Re: Safelight Glass- Warren Avenue

Safelight has asked me to contact you regarding their proposal to move their dumpster area to near the building so that it is easier for them to access it. See the attached plans. They propose a concrete slab with a chain link fence with vinyl slats for screening around the waste area. Will you need any further info on this?

*Jean Fraser, Planner
City of Portland
874 8728*

SHEET TITLE
**SITE LAYOUT AND
UTILITY PLAN**

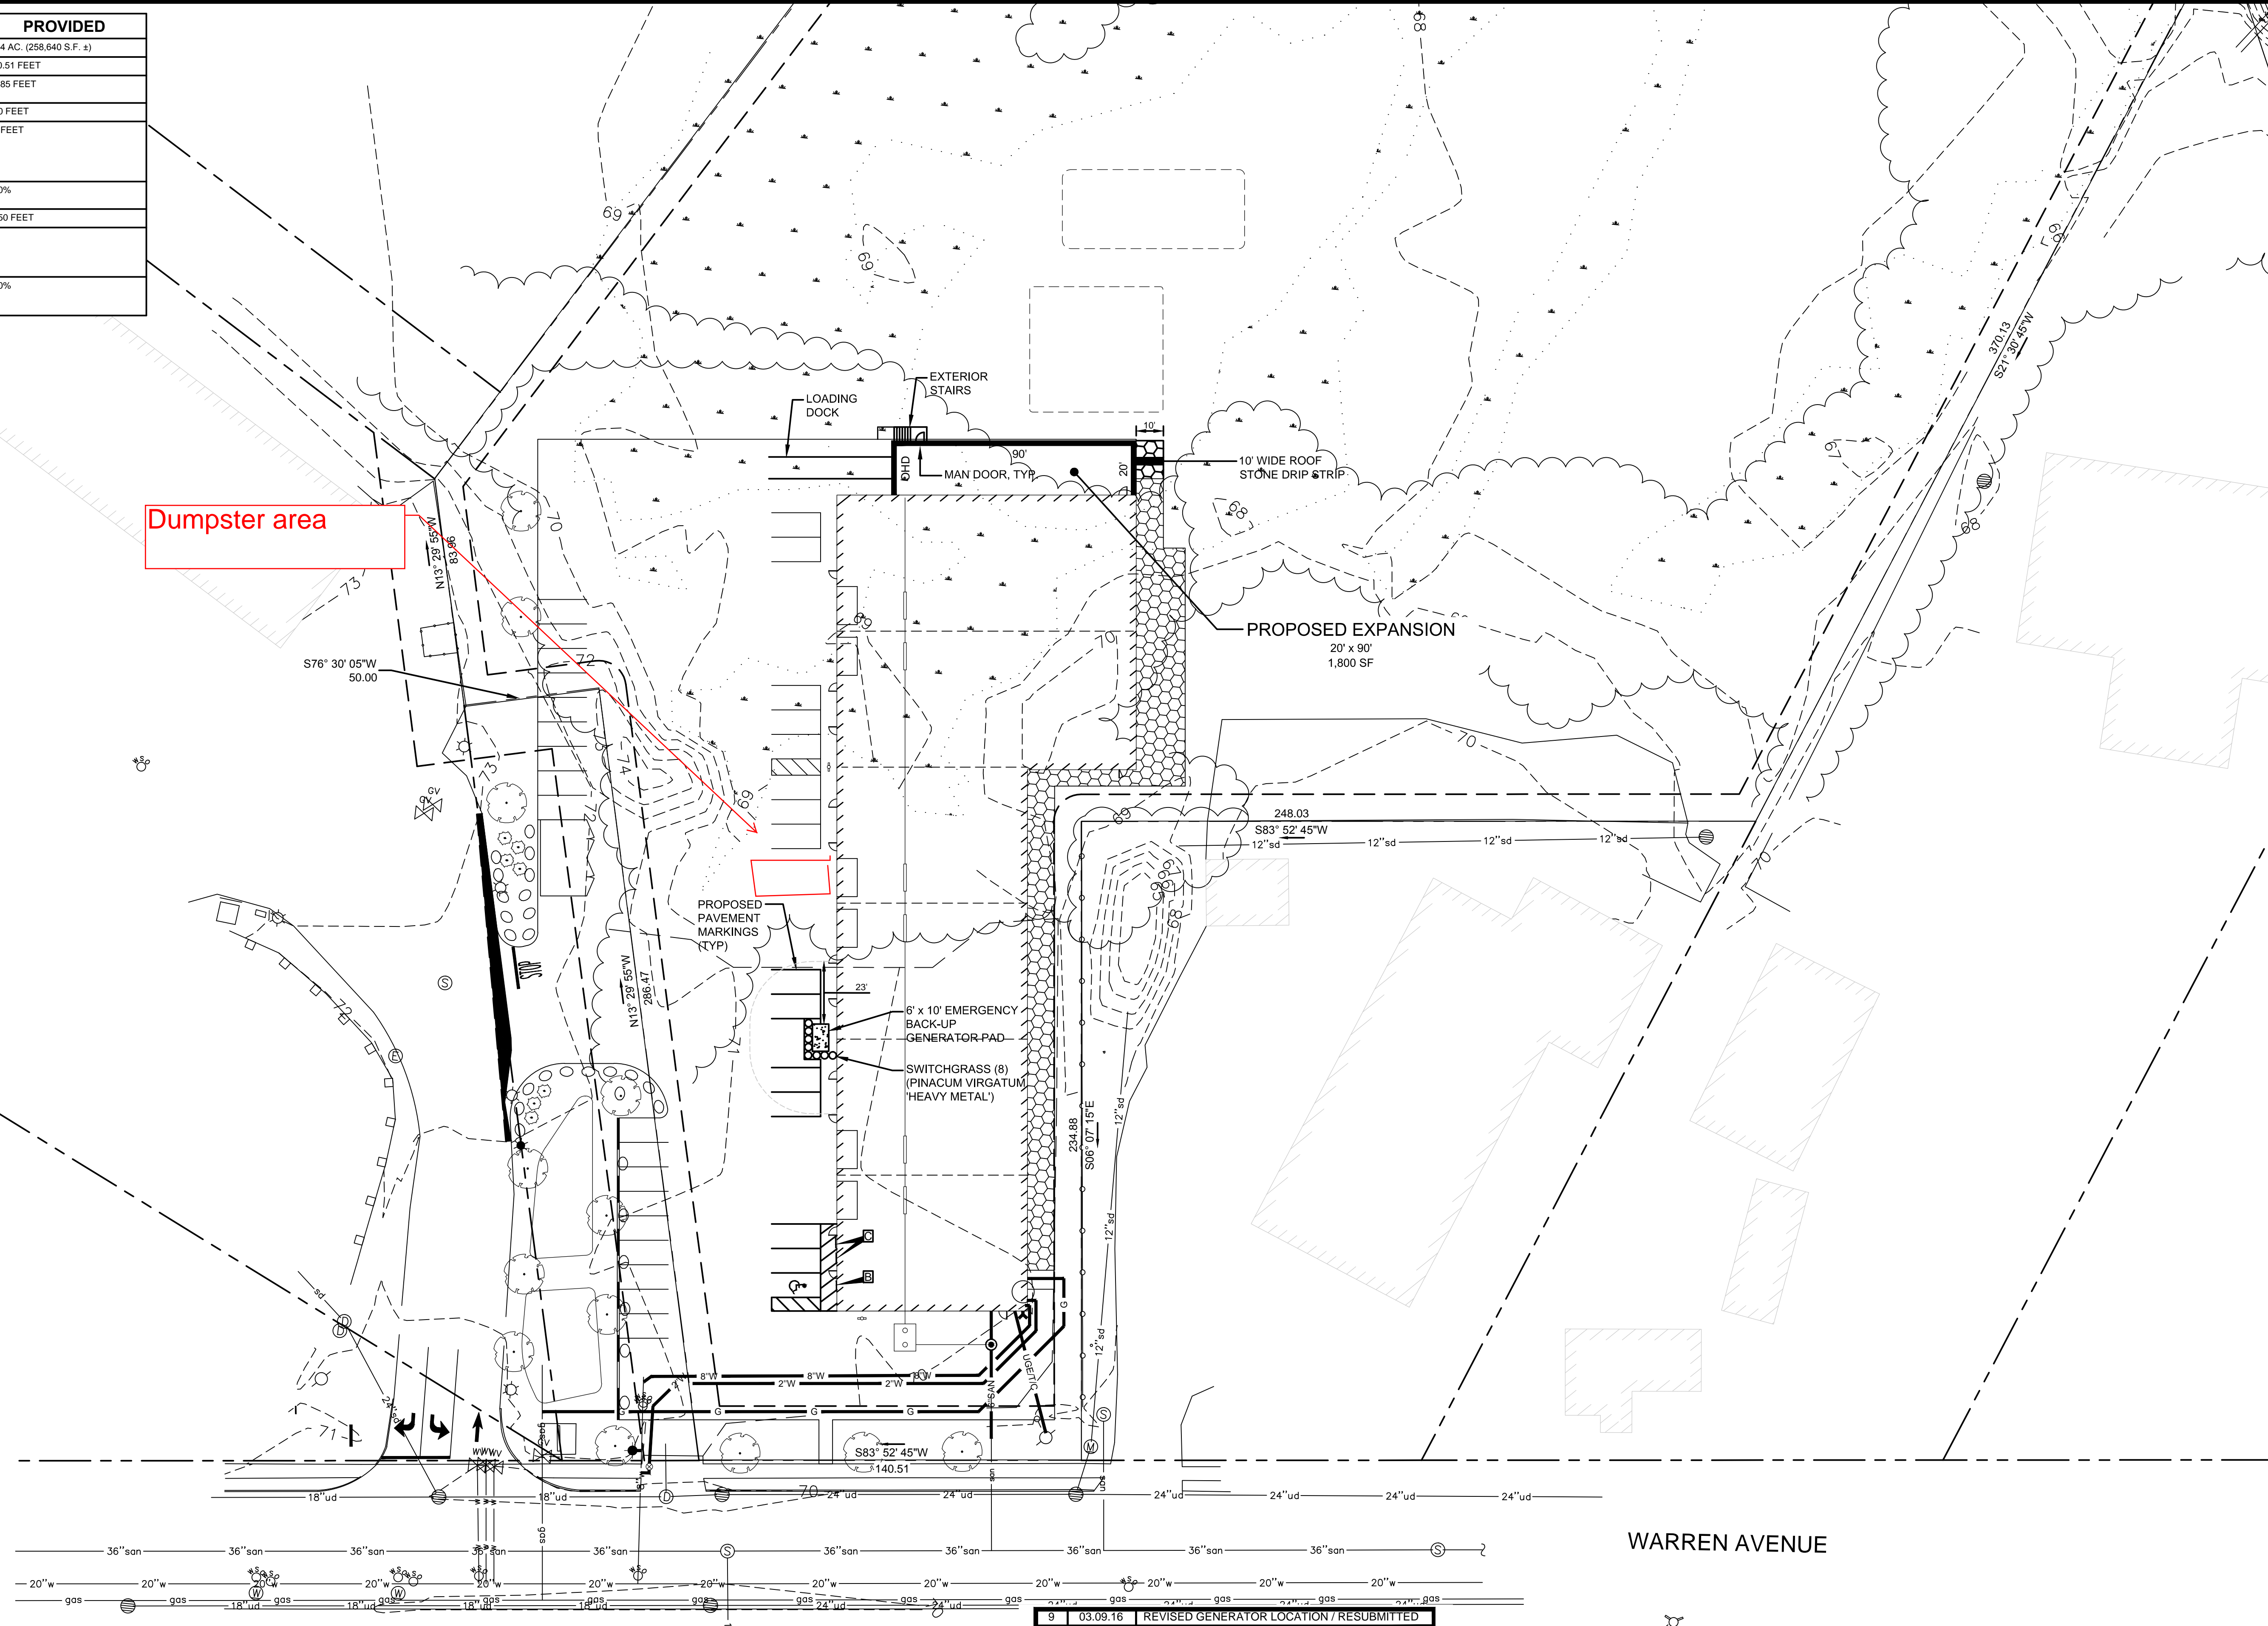
I think you are aware that this proposal does not comply with site plan requirements both in terms of its location and in terms of its lack of screening (see Site Landscaping part of the Ordinance).

I suggest that it be located in the top left corner and the proposal should include some kind of screening from west and south as per the ordinance.

All new developments along Warren have tried to locate their dumpsters along these lines. This is a brand new facility and if this had been in the original submissions for review it would not have been approved.

**A-1.1**

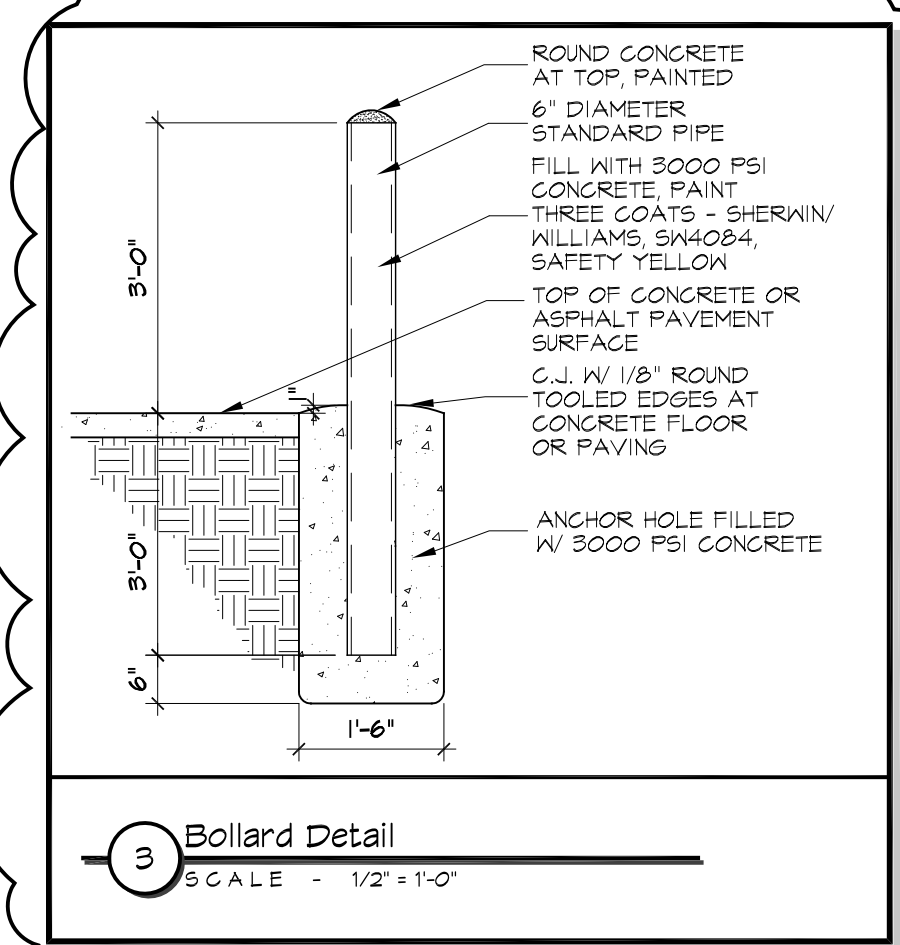
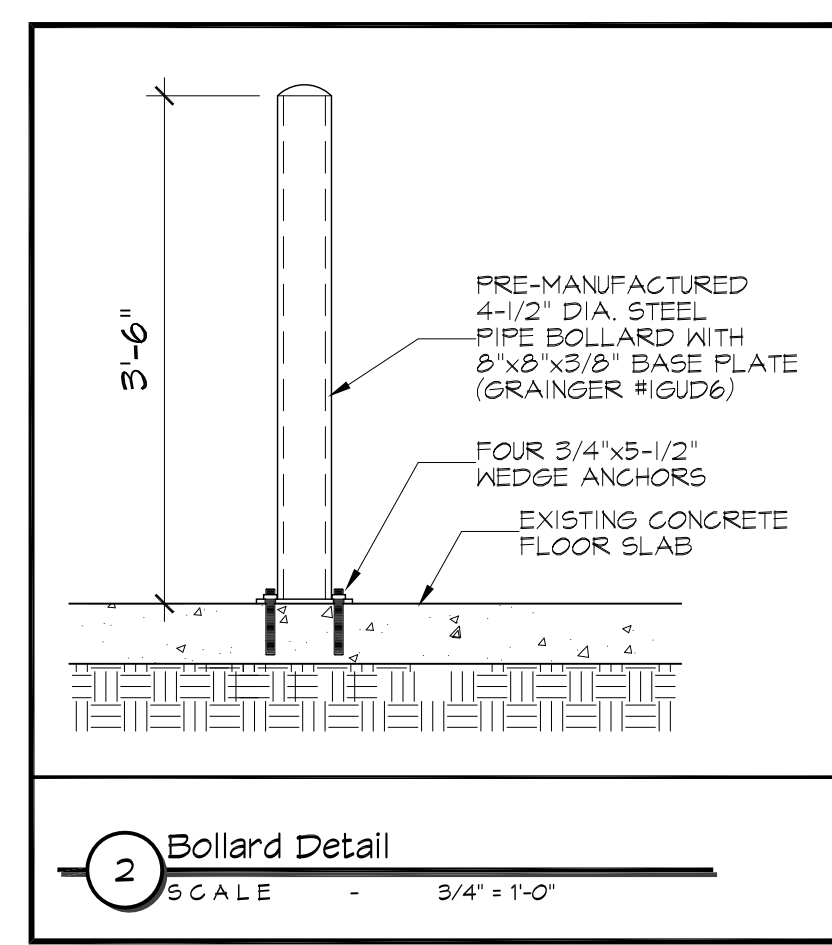
The person I was liaising with re the HVAC still needs to send some info re that and it needs a better enclosure.
